Parkside Neighborhood Center & Affordable Housing

77 & 85 Grant Street

March 24, 2004

RE: PROP, Parkside Neighborhood Center and Affordable Housing, Portland, ME
CBL: 0486011

EAST ELEVATION BUILDING B

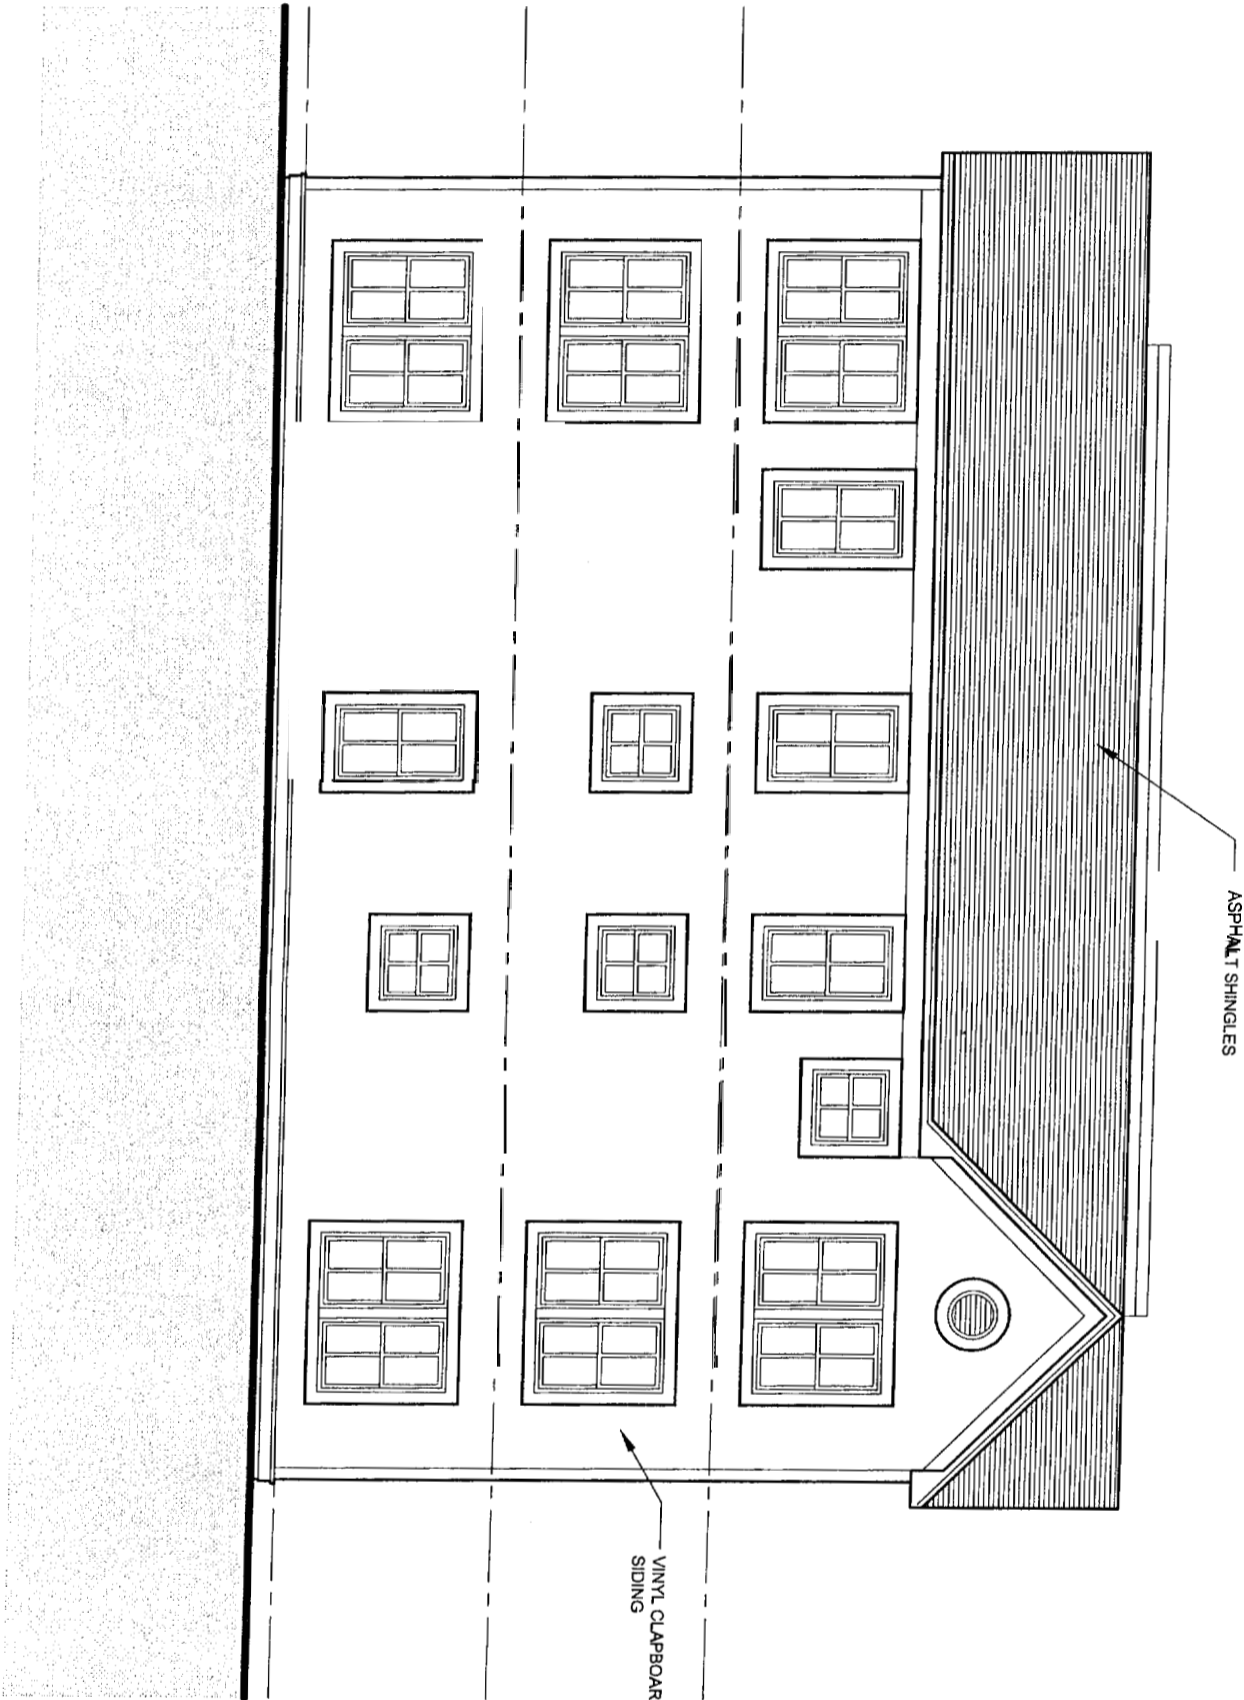
Building **B** to eastern Abutter - due to the proximity of our proposed building to the potential of an abutting building to the east, we will increase the fire assembly rating of the exterior wall along the eastern side to 1 hour per Table 705.2. I have attached the UL assembly that we intend to use.

Per my previous letter we will reduce the unprotected openings to below the 15% allowed by table 705.3. I've included the calculations again below for your reference.

- Area of the East wall of Building **B** = **1493.5 SF**
- As submitted, area of unprotected openings on the East wall of Building **B** =

Large dbl hung windows	14 x 14.1 SF =	197.4 SF
Small dbl hung windows	4 x 8.0 SF =	32.0 SF
Misc. louvers, vents =		3.9 SF
Total		233.3 SF

Therefore as submitted we have-

$1493.5 \text{ sf} \times 15\% = 224.0 \text{ sf}$ allowed, proposed = 233.3 sf, +9.3 sf

With the reduction of 3 large double hung windows we will bring the opening area down to 191 sf, or 42.3 sf below the minimum allowed.

EAST ELEVATION BUILDING A

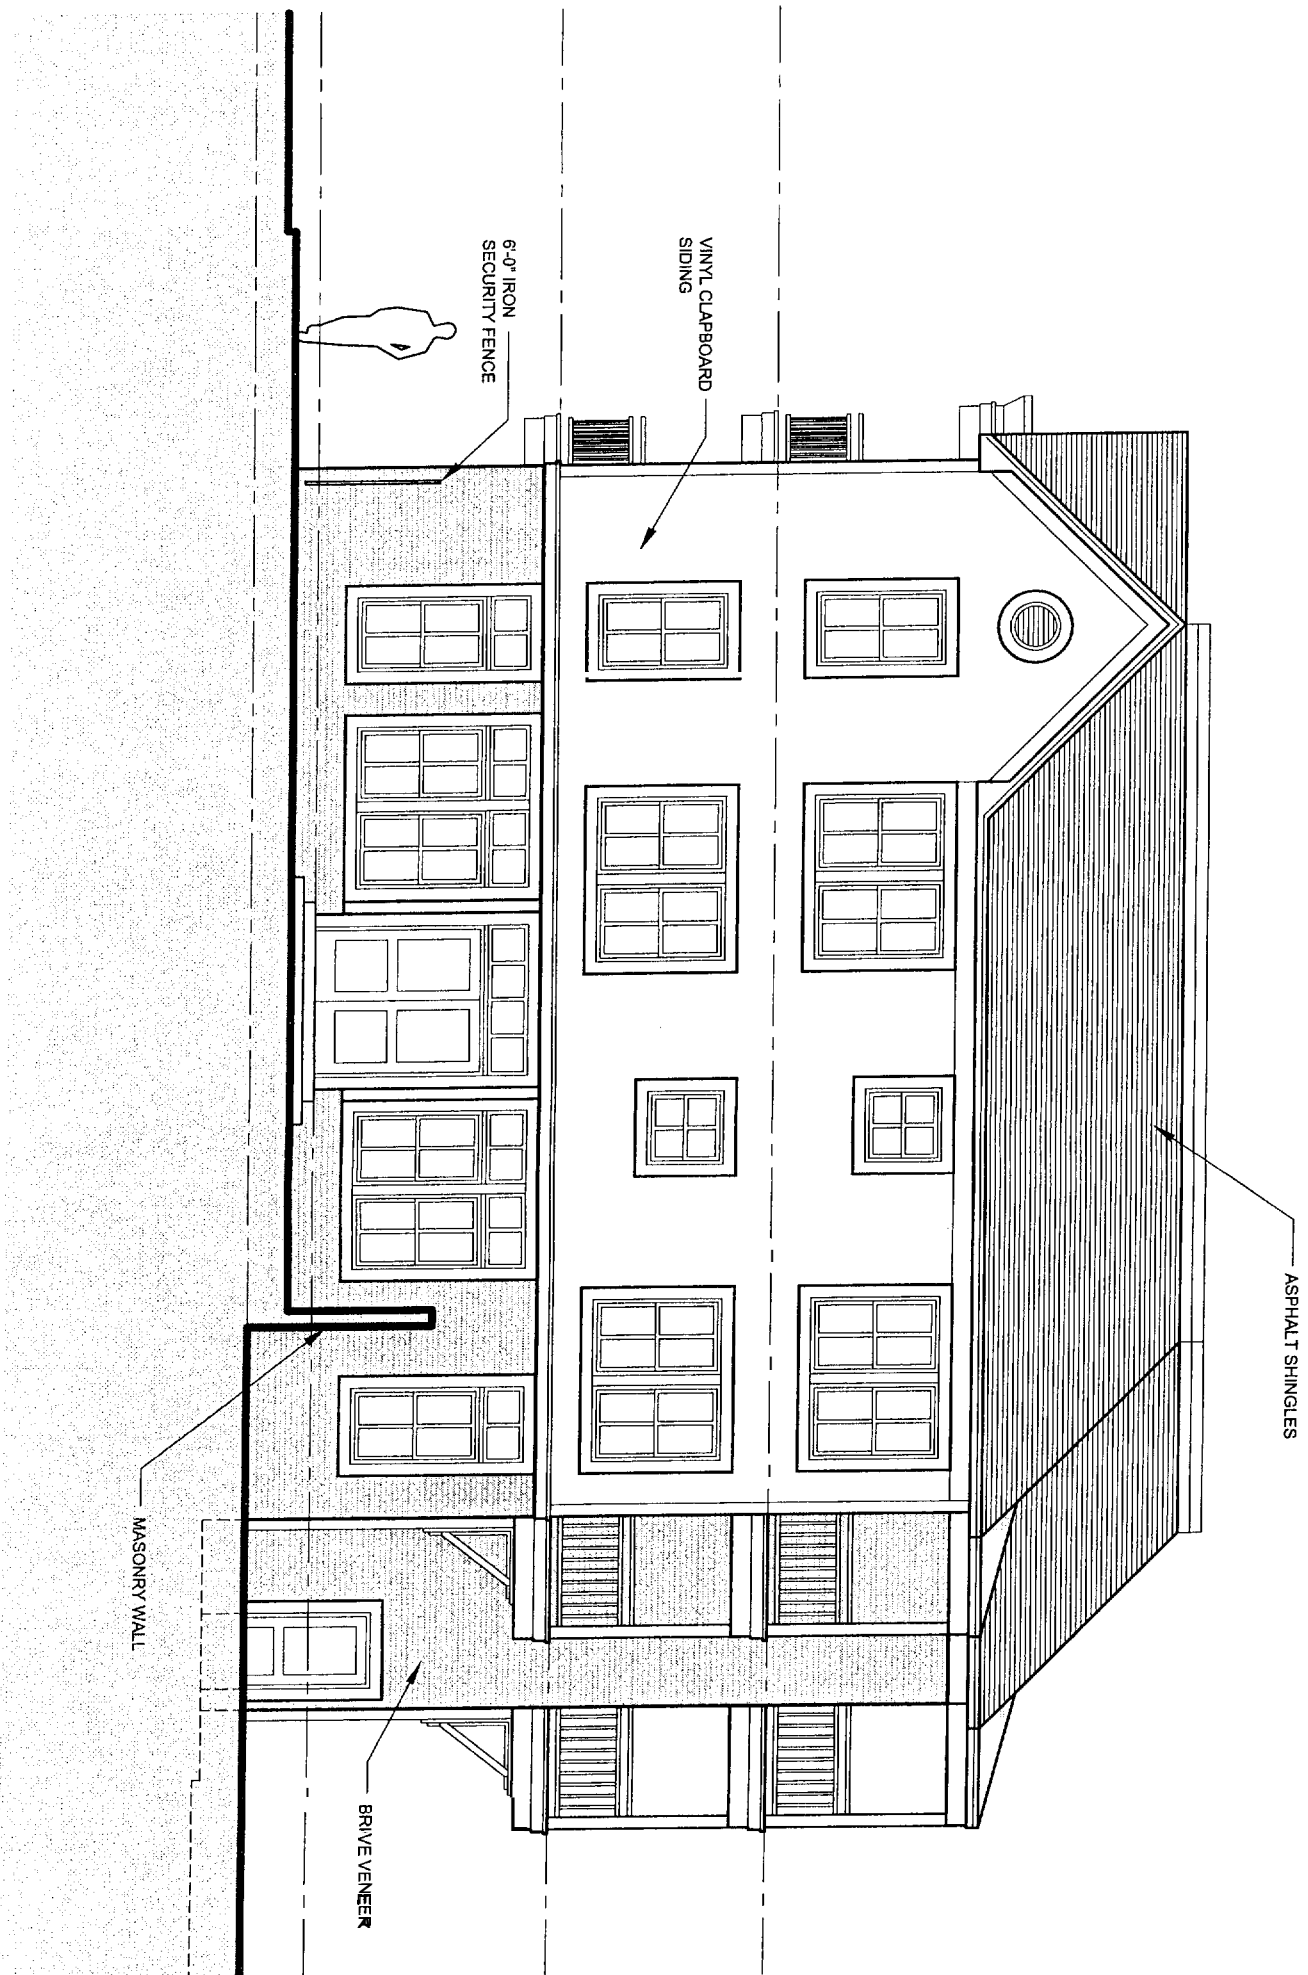
For the east wall of Bldg. A and west wall of Bldg B, after reviewing Section 705.1 the first exception does not require compliance to maximum exterior opening areas if the combined building limits for all buildings on the same lot fall within Section 503 limits. Therefore the eastern wall of Bldg **A** requires no modification from our submitted plans.
